Householder Proforma

Application Ref: 2021/0788

Address: 14 Highfields, Hoylandswaine, Barnsley, S36 7JP

Proposed: Alterations to dwelling including raising of roof, addition of dormers, balcony and rendering of property

TITLE:
Existing & Proposed Elevations

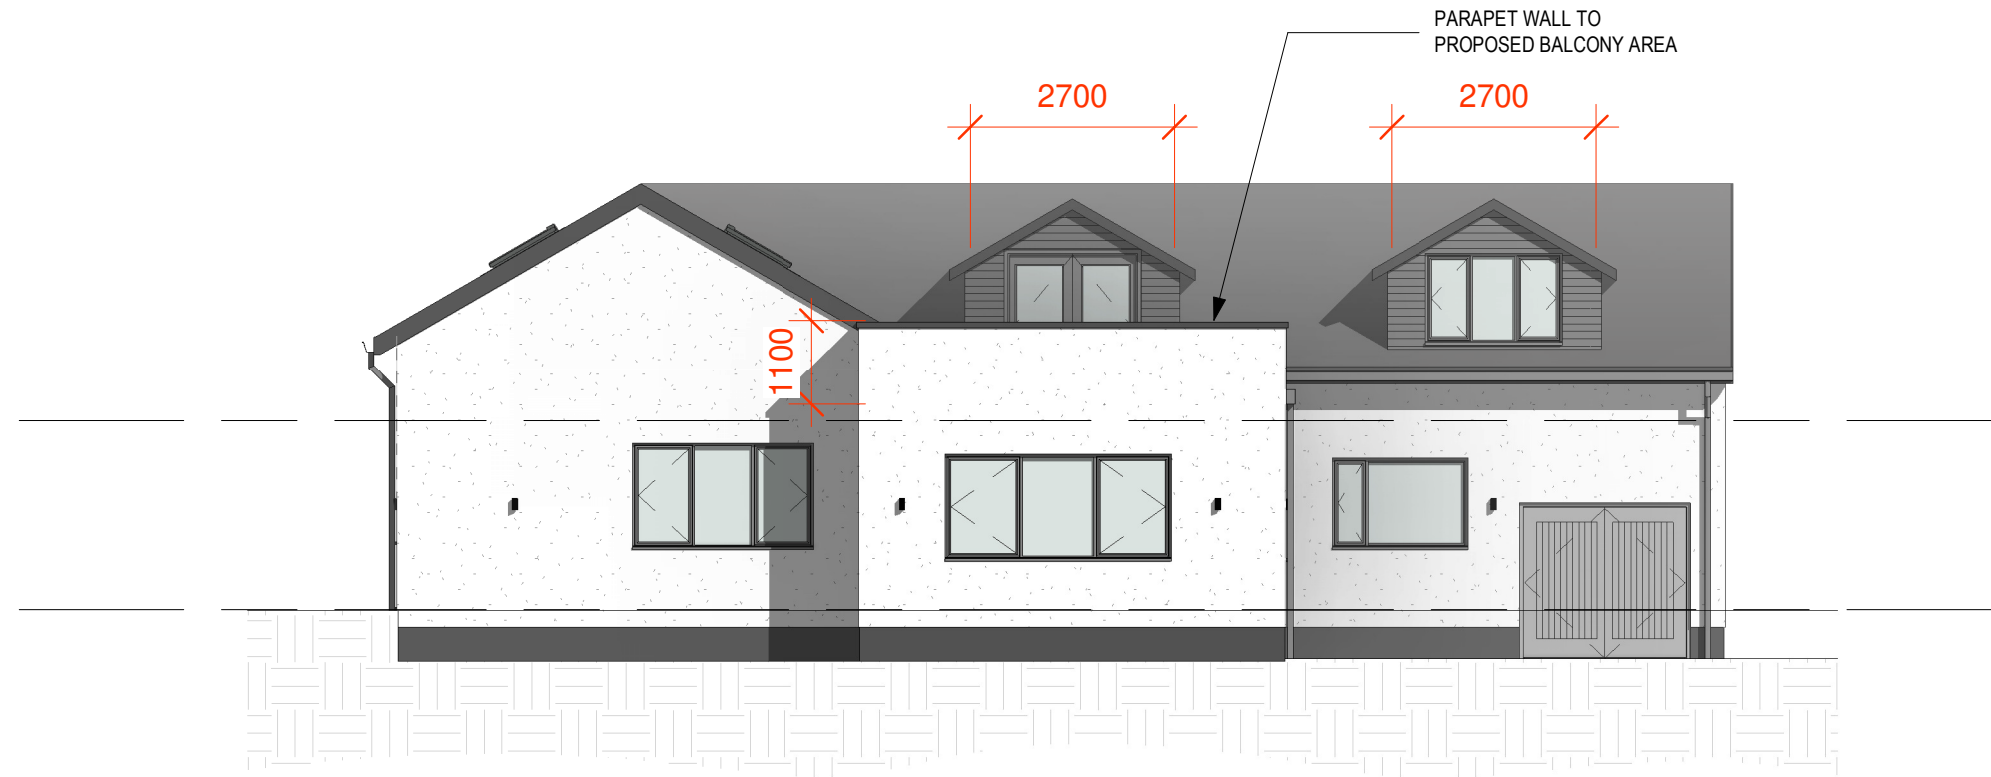
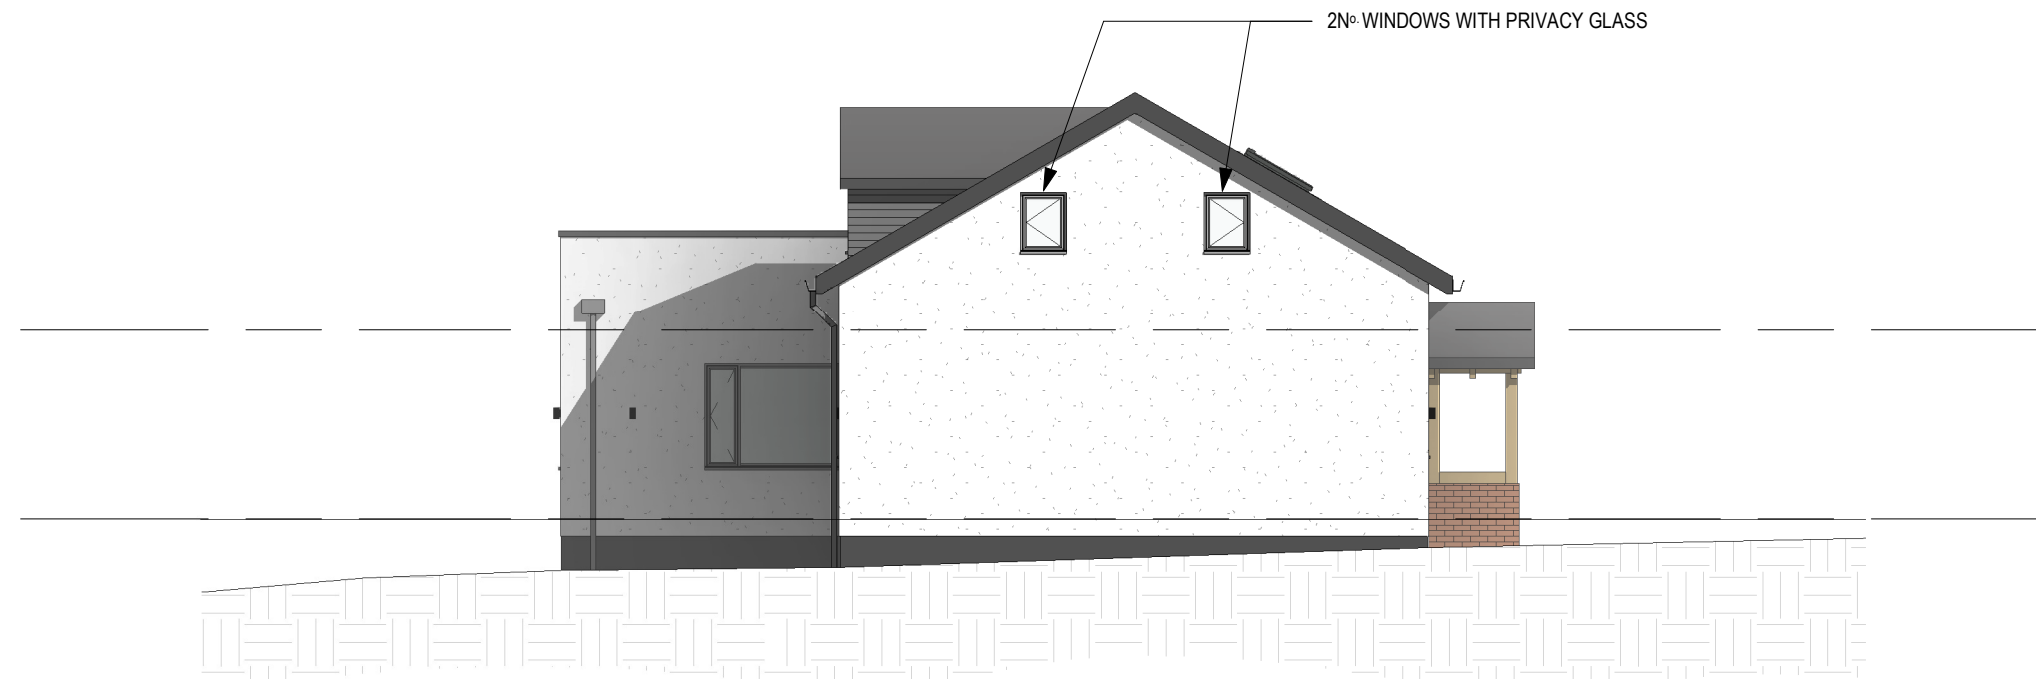
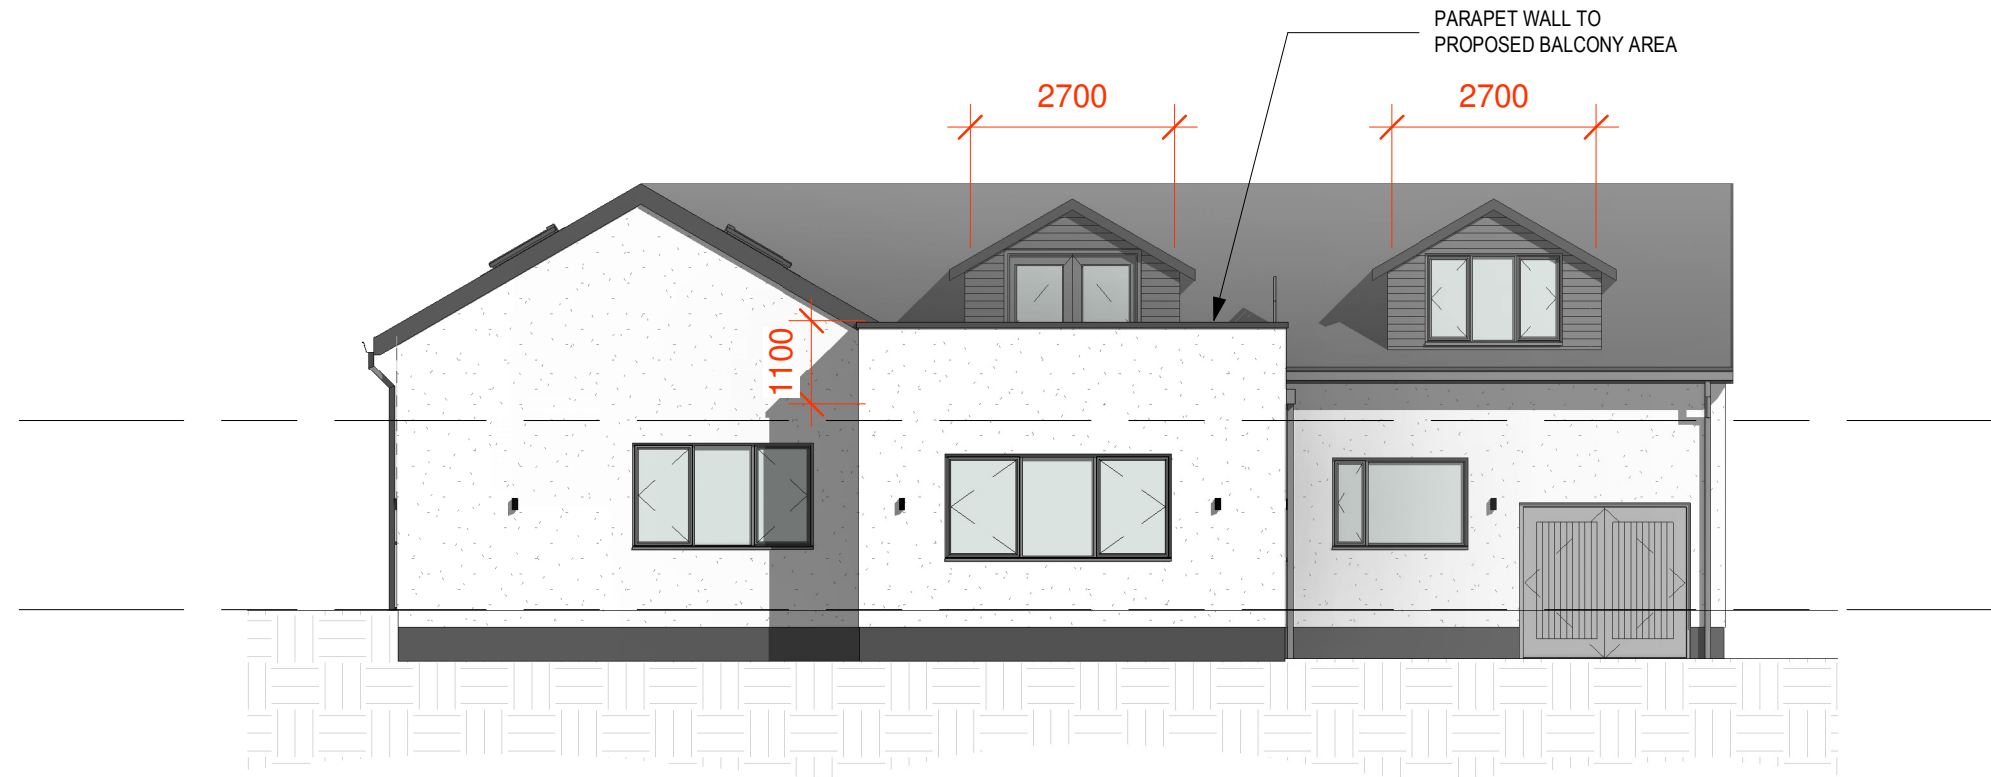
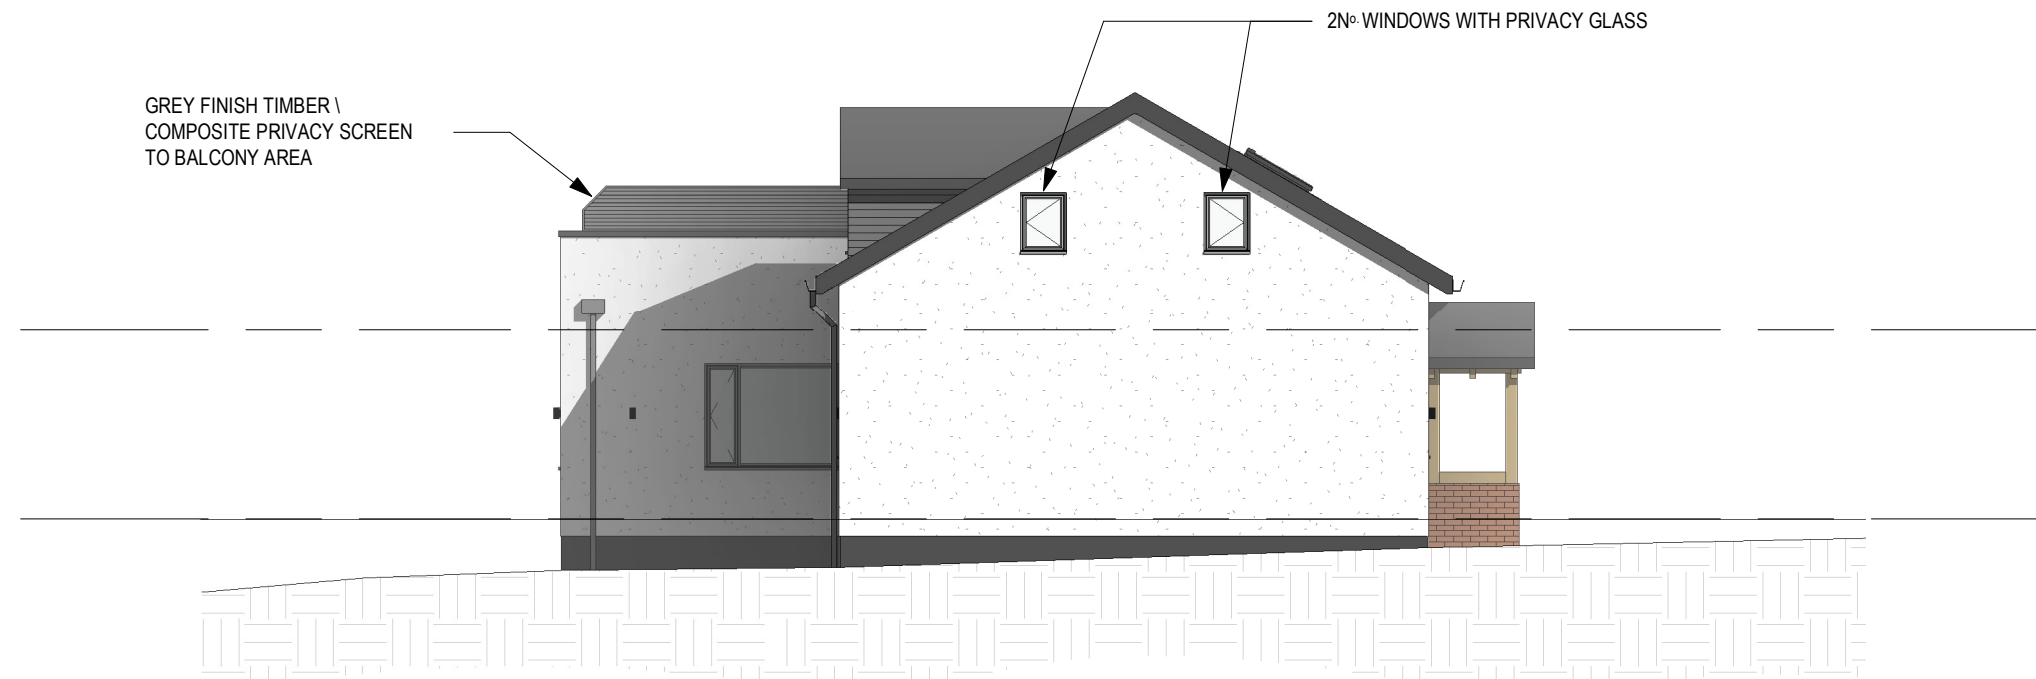
Single Storey	
1. terraced property and less than 3.5m (projection to rear)?	
2. semi-detached and less than 4m?	Existing rear extension – balcony proposed to this structure.
3. if more than 3m are the eaves more than 2.5m in height?	
Two Storey	
4. terraced property and less than 2.5m (projection to the rear)?	
5. semi-detached and less than 3.5m?	
All	
6. materials to match	The whole property will be rendered
7. roof design compliments / ties in well	Proposal for 1m wall to sides of existing extension to create balcony. Screening to west elevation which will protect amenity value of No. 16 garden area. The screening is proposed grey finish timber/composite

material to tie into the proposed roof and dormer windows.
8. habitable room windows on the side elevation?	
9. distance to rear boundary (shared with another residential property) 10m or more?	Yes – distance to rear boundary is over 11m. Haigh Head Road provide further separation to boundary of No 2 Haigh Head Road and Tree Tops.
